From: Amber Willard
Sent: 16 October 2018 08:56
To: Karen Parsons
Subject: FW: FP/144/18/HH

From: Amber Willard [mailto:Amber.Willard@arun.gov.uk]
Sent: 12 October 2018 14:16
To: [REDACTED]
Subject: FP/144/18/HH

I was reallocated your application FP/144/18/HH a few days ago. I am about to start writing up the recommendation report, however I think one of the plans may have been scaled incorrectly. Its drawing title is 'Proposed site layout' and it shows the ground floor plan on it. The scale says 1:50 although I think it just needs to be amended to 1:100.

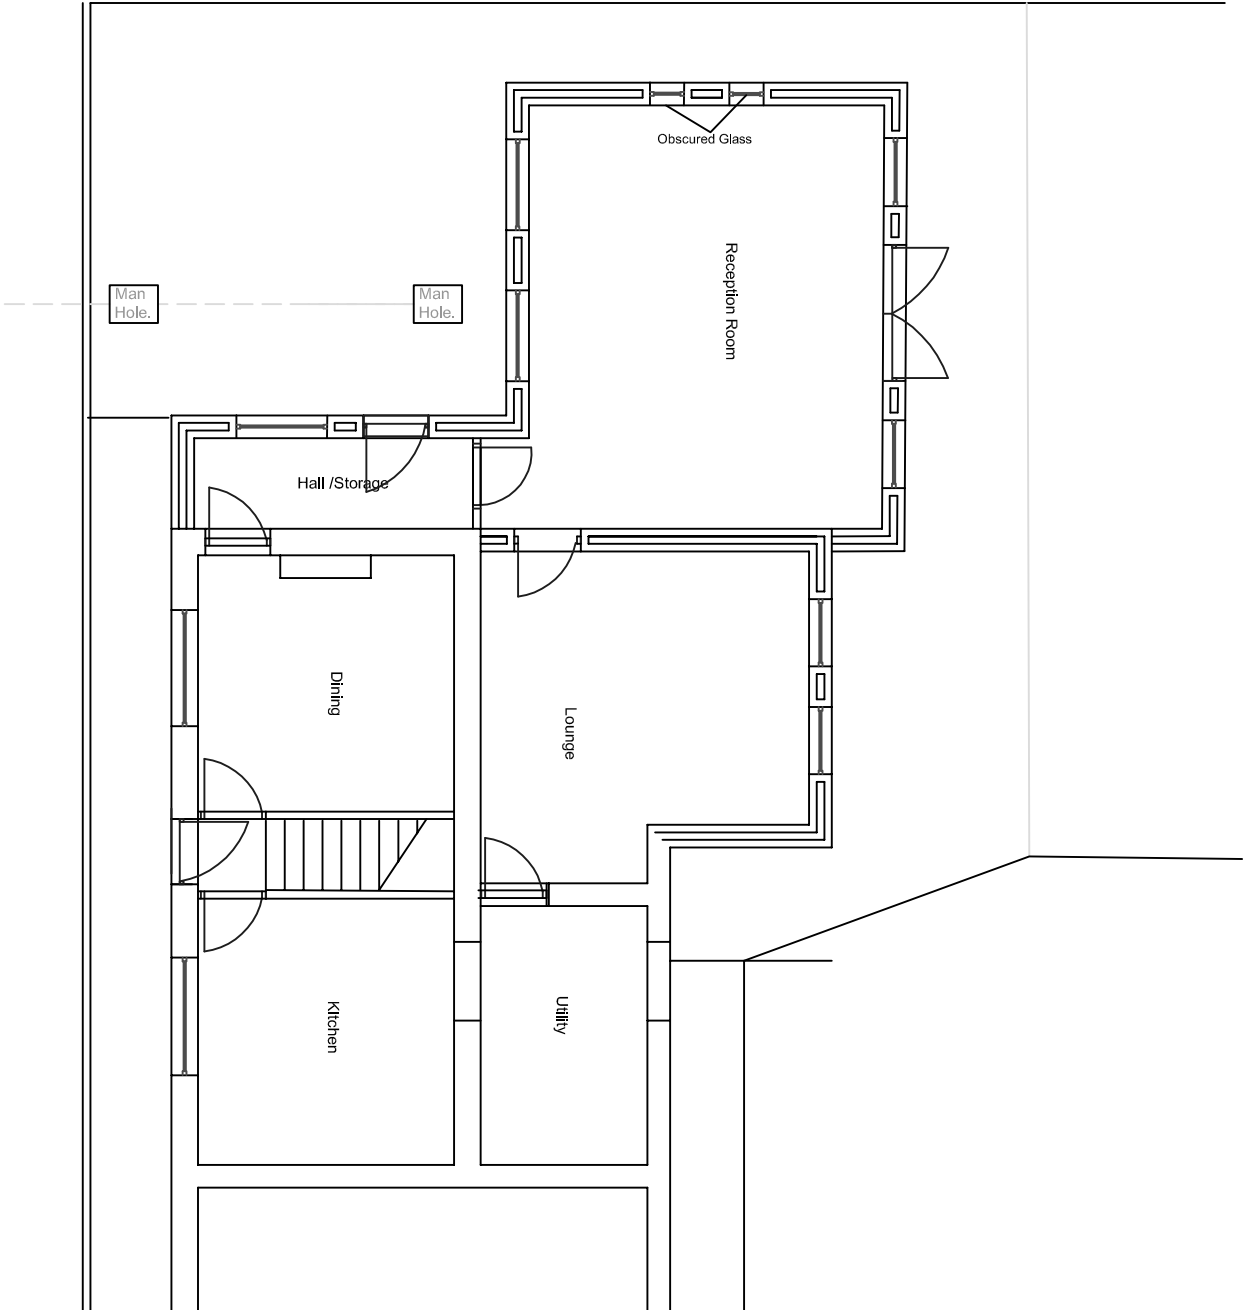
Please am I able to get this amended.

Please find attached amended drawing with the correct scale to 1:100
